The Drovers Solar Farm

Statement of Common Ground (SoCG) with Environment Agency (Tracked)

Document reference: APP/5.13.2 (Revision 2)

DRAWING TITLE:
Figure 12.14: Work No. 3 Maximum Potential Foundations and Groundwater Elevations

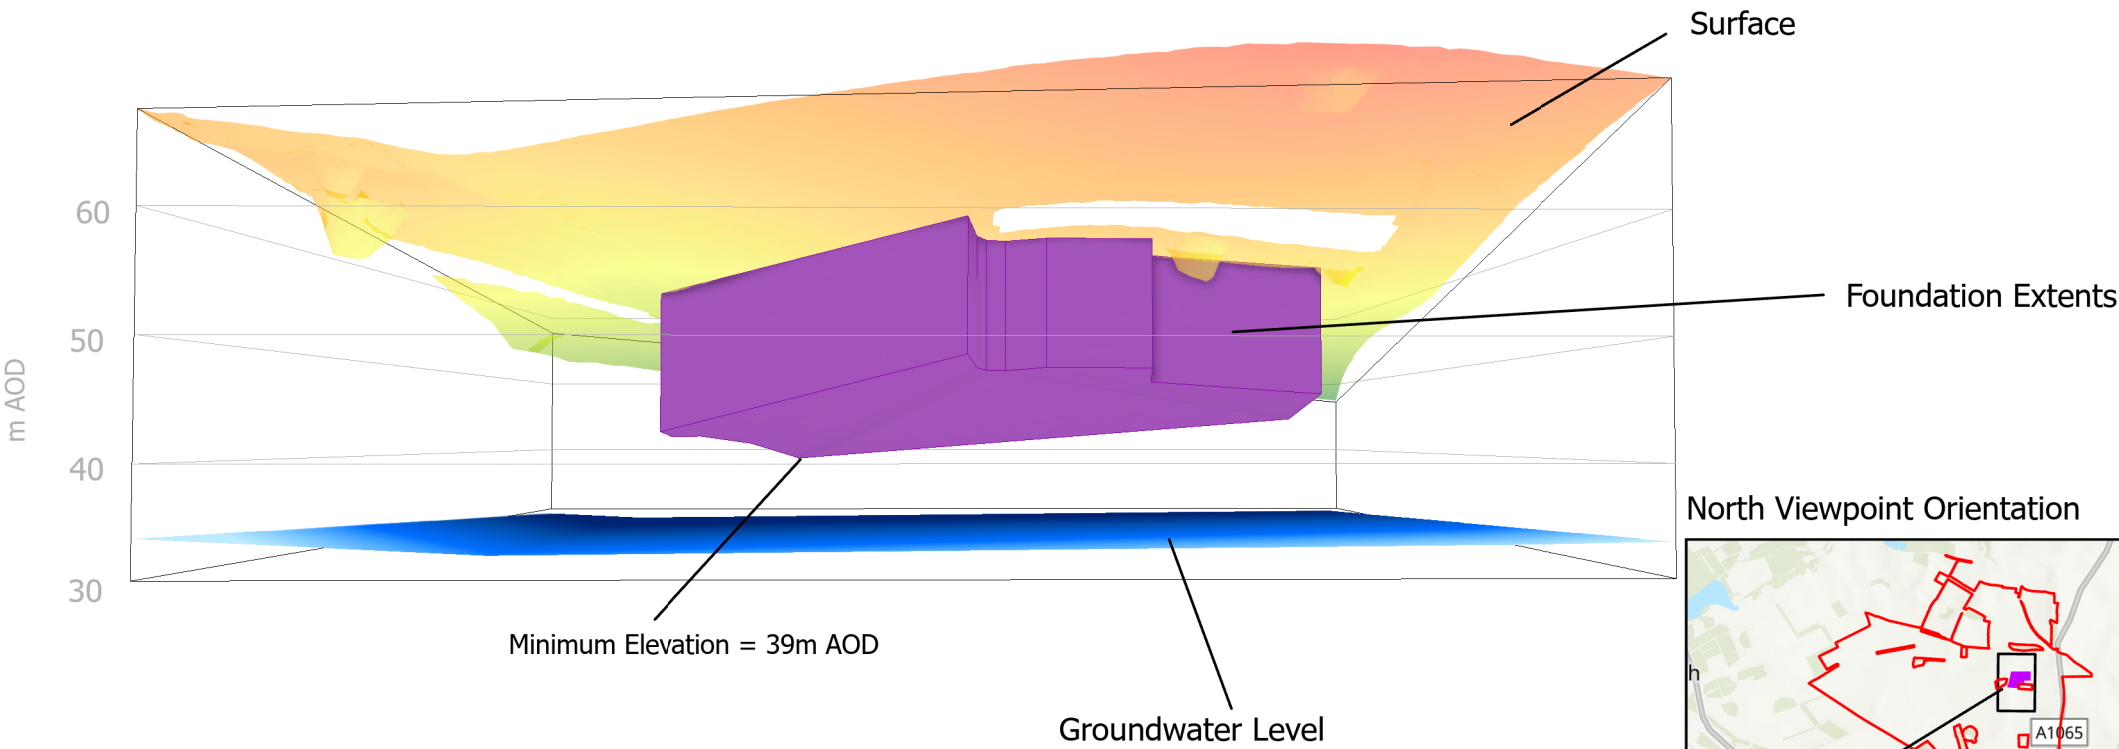
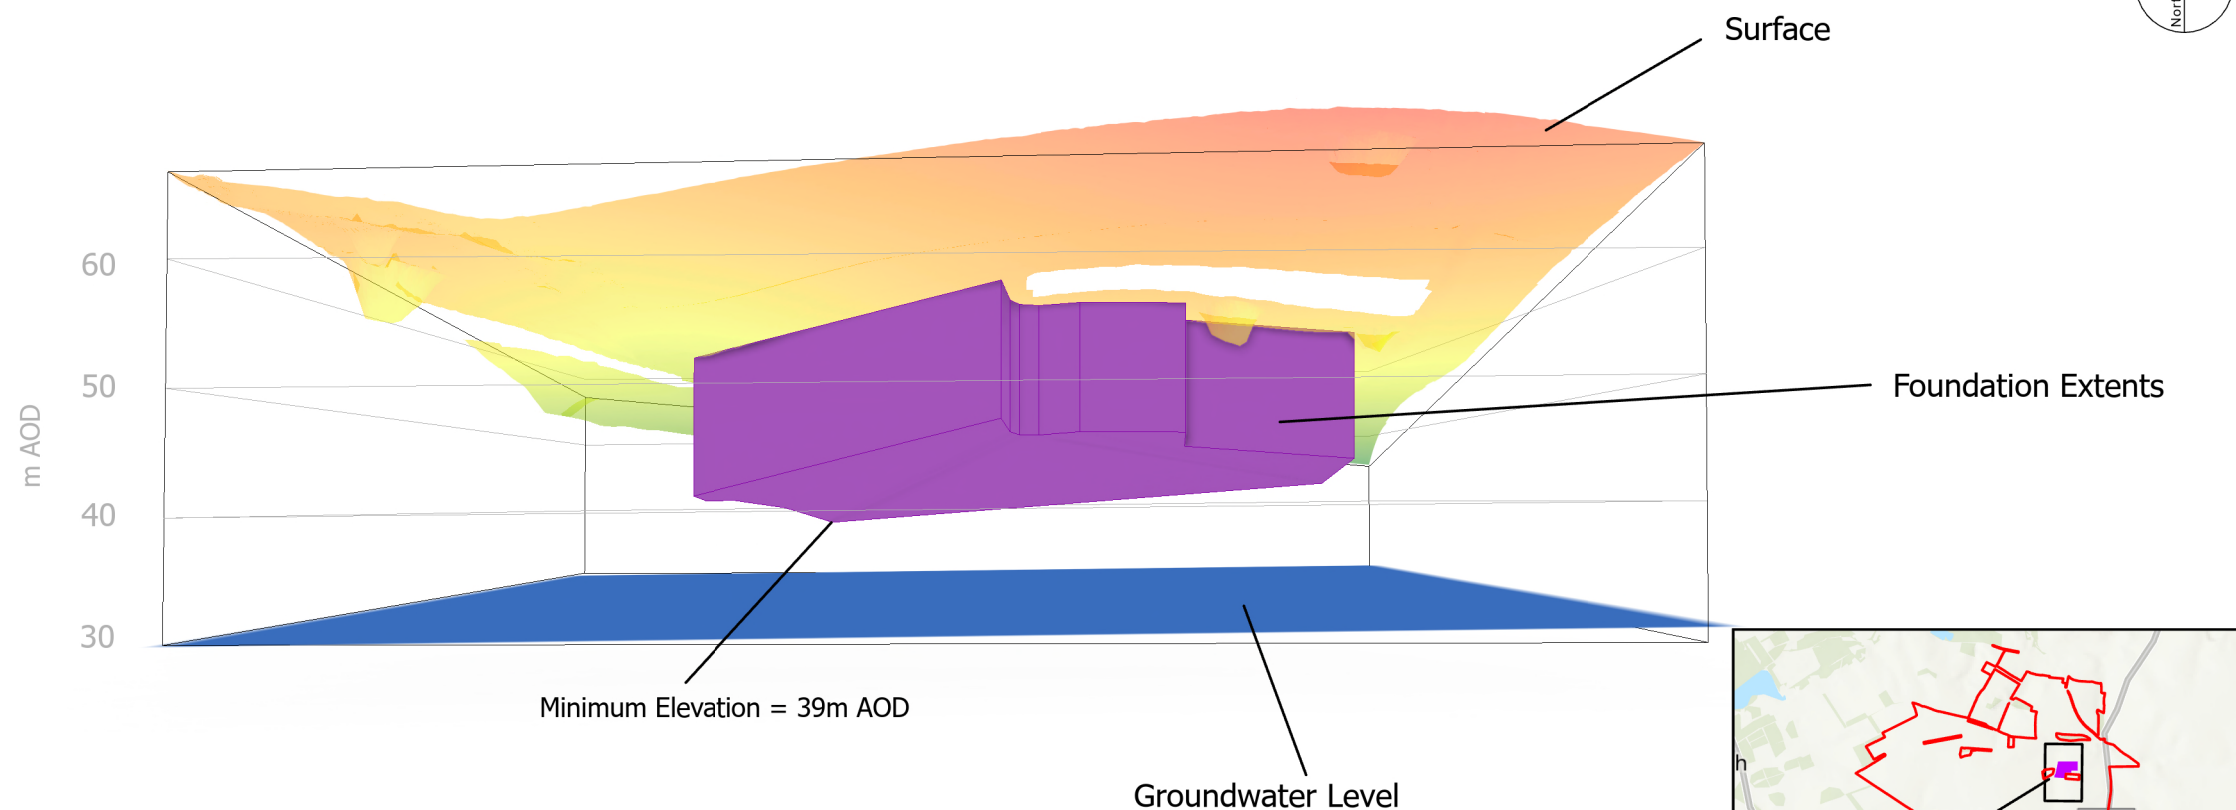
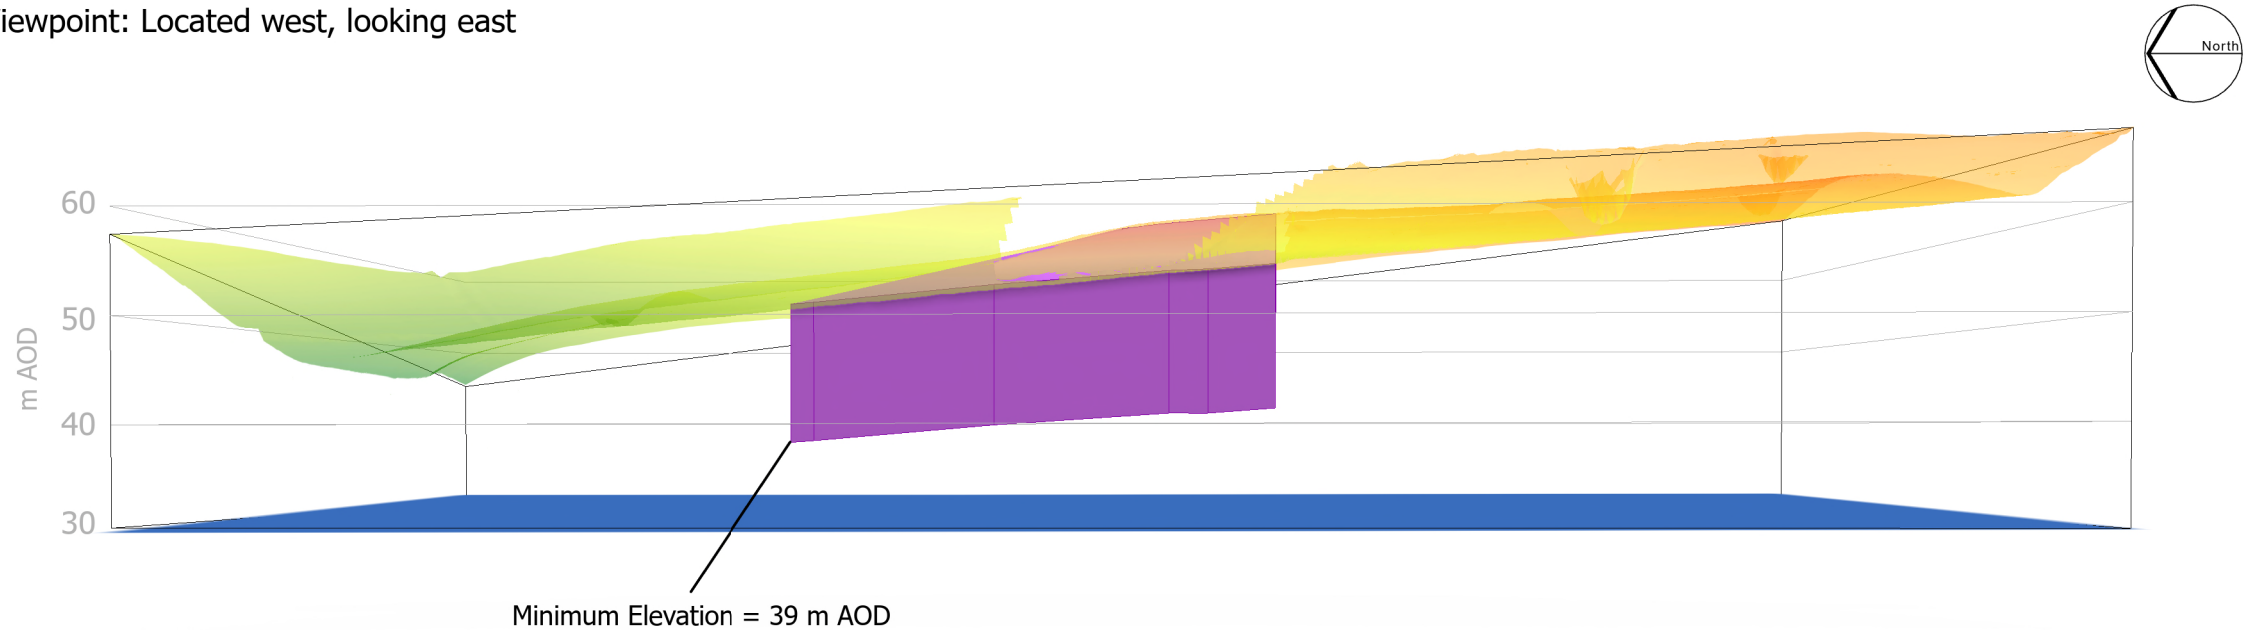
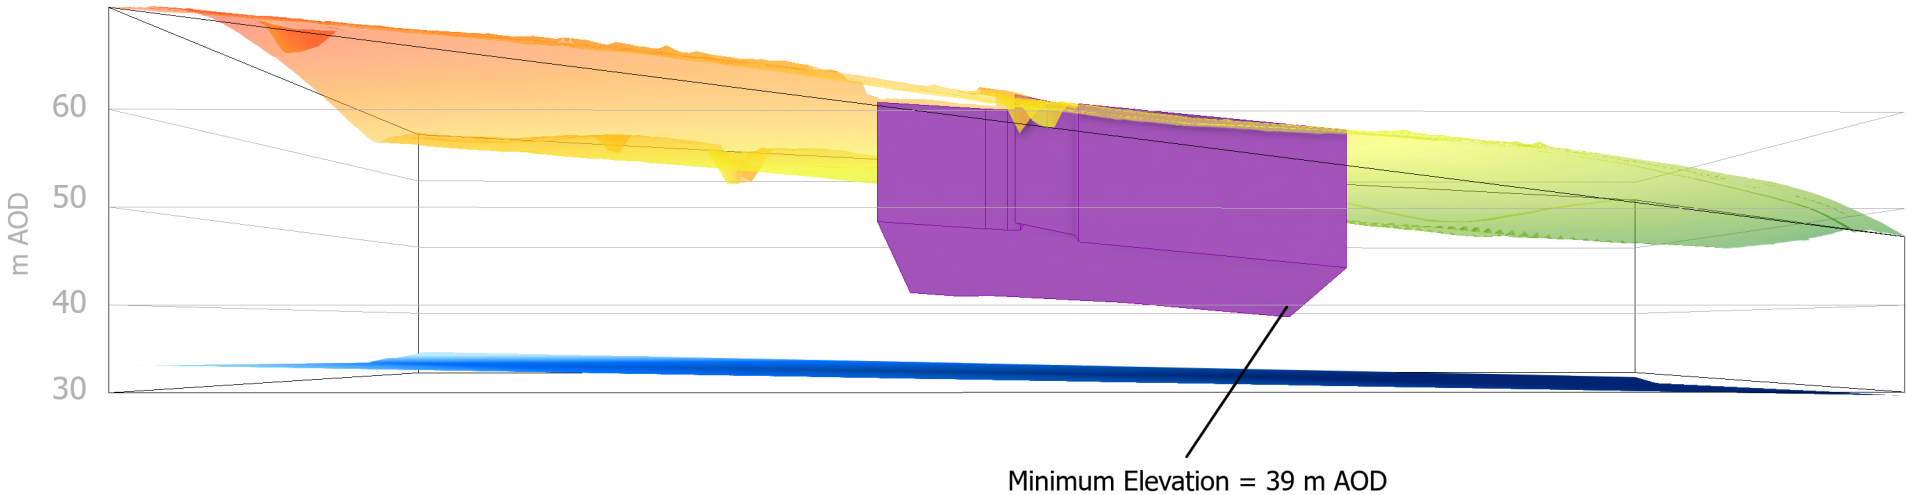
Figure 12.14 Work No. 3 Piling Locations within CSA for Maximum Groundwater Level [APP 128]– Figure 12.15 Work No. 4 Piling Locations within CSA for Maximum Groundwater Level [APP 129]– Figure 12.16 Maximum Foundation Extents for Minimum Groundwater Level [APP 130]– Issue: Figures 12.13 to 12.16 do not clearly show the orientation of each 3D model view, and the elevation of the maximum extent of foundations is not given.– Impact: Difficulty in interpreting figures.– Solution: Revise figures to more clearly define the area represented in the drawings, including view orientation, and the maximum foundations extent should be shaded to show elevation values. The model should be updated to inform detailed foundation design, based on site specific survey and monitoring data.– Additional Comments: Use of inconsistent terminology may also result in confusion. Figures 12.13 to 12.15 are titled to show the anticipated extent of piling in comparison with the maximum groundwater level. In the context of the data presented, the maximum groundwater level in mAOD represents the shallowest extent and therefore worst-case condition for groundwater. For clarity the	proposed foundation depths could theoretically intercept shallow groundwater under worst-case conditions. The figures also demonstrate at a concept level where piling may be required depending on foundation design. The following changes have beenwere made at Deadline 3 to aid the EA's interpretation: • Addition of orientation labels or description • Elevation shading to show mAOD values for the maximum groundwater elevation surface and foundation extent surface • Highlight areas where foundations intersect or exceed groundwater elevation surfaces; and • Figures and text refer to groundwater elevation (mAOD) rather than groundwater level to increase clarity between absolute elevation and depth below ground. The Applicant agrees that the conceptual model present is not the final tool for foundation design, but rather to provide a screening-level assessment of groundwater conditions and to identify areas needing piled or shallow foundations and will be aligned with EA regional groundwater understanding (NEAC model). The Design Principles,

report should preferably refer to groundwater 'elevation' (in mAOD) as is represented within the figures rather than 'level', which could be misinterpreted as relative to ground level rather than Ordnance Datum. Figure 12.16 shows the minimum (i.e. deepest) groundwater elevation (i.e. best case) in relation to anticipated piling depth. Although this is useful information, this could potentially be misinterpreted by the reader as presenting a combined overview of the information provided in Figures 12.13 to 12.15. We are satisfied and consider this issue resolved. We were concerned that figures 12.13 [APP-127], 12.14 [APP-128], 12.15 [APP-129] and 12.16 [APP-130] do not clearly define the area represented by the drawings, including view orientation, or the elevation values. We have reviewed the following: • 6.3.1 ES Figure 12.13 Work No. 2 Maximum Potential Foundations and Groundwater Elevation [REP3-043] • 6.3.1 ES Figure 12.14 Work No. 3 Maximum Potential Foundations and Groundwater Elevation [REP3-044]	Parameters Commitments [APP/5.8.34] have been<u>was</u> updated at Ddeadline 2 to commit to foundations not directly interacting with groundwater. <u>The Applicant maintains the position that a potential interaction of up to 1 m has been determined for a very small section of Work No. 4 and that Figure A12-1-10 displays this minimal interaction northeast of Work No. 4, should the full Work No. be developed.</u>

• <u>6.3.1 ES Figure 12.15 Work No. 4 Maximum Potential Foundations and Groundwater Elevation [REP3-045]</u> <u>We find the updated figures satisfactory for defining the 3D model view, and elevation the maximum extent of the foundations</u>		
2-2	EA38	Storage of Waste Batteries	<u>We are satisfied and consider this issue resolved.</u> <u>We were concerned that there was an absence of mitigation measures relating to the storage of waste batteries.</u> <u>The 7.14.1 outline Battery Safety Management Plan (Tracked) [REP3-072] has been updated to include suitable measures. We cannot resolve this issue. We were concerned that there was an absence of mitigation measures relating to the storage of waste batteries. The Applicant has stated in 8.4 Applicant's Response to Relevant Representations [REP1-067]: "End-of life or damaged BESS units are to be electrically disconnected from the system when identified as being required. When disconnecting damaged or defective units, a specific risk assessment shall be conducted prior to the removal of the defective module to ensure the safety of employees and contractors. Damaged or defective units will be inspected and placed in an approved protective container prior to being</u>	An outline Battery Safety Management Plan (oBSMP) [APP/7.14.2APP-194] has been prepared as part of the DCO Application which sets out the mitigation measures to be secured via Requirement 6 of the draft DCO [APP/3.1.14]. <u>The oBSMP [APP/7.14.2] has been updated at Deadline 4 to confirm the management of damaged or end-of-life batteries by the following:</u> End-of-life or damaged BESS units are to be electrically disconnected from the system when identified as being required. When disconnecting damaged or defective units, a specific risk assessment shall be conducted prior to the removal of the defective module to ensure the safety of employees and contractors. Damaged or defective units will be inspected and placed in an approved protective container prior to being transported from Site, to ensure against any risk of contaminants entering ground- or surface water. End-of-life batteries awaiting	LowAgreed
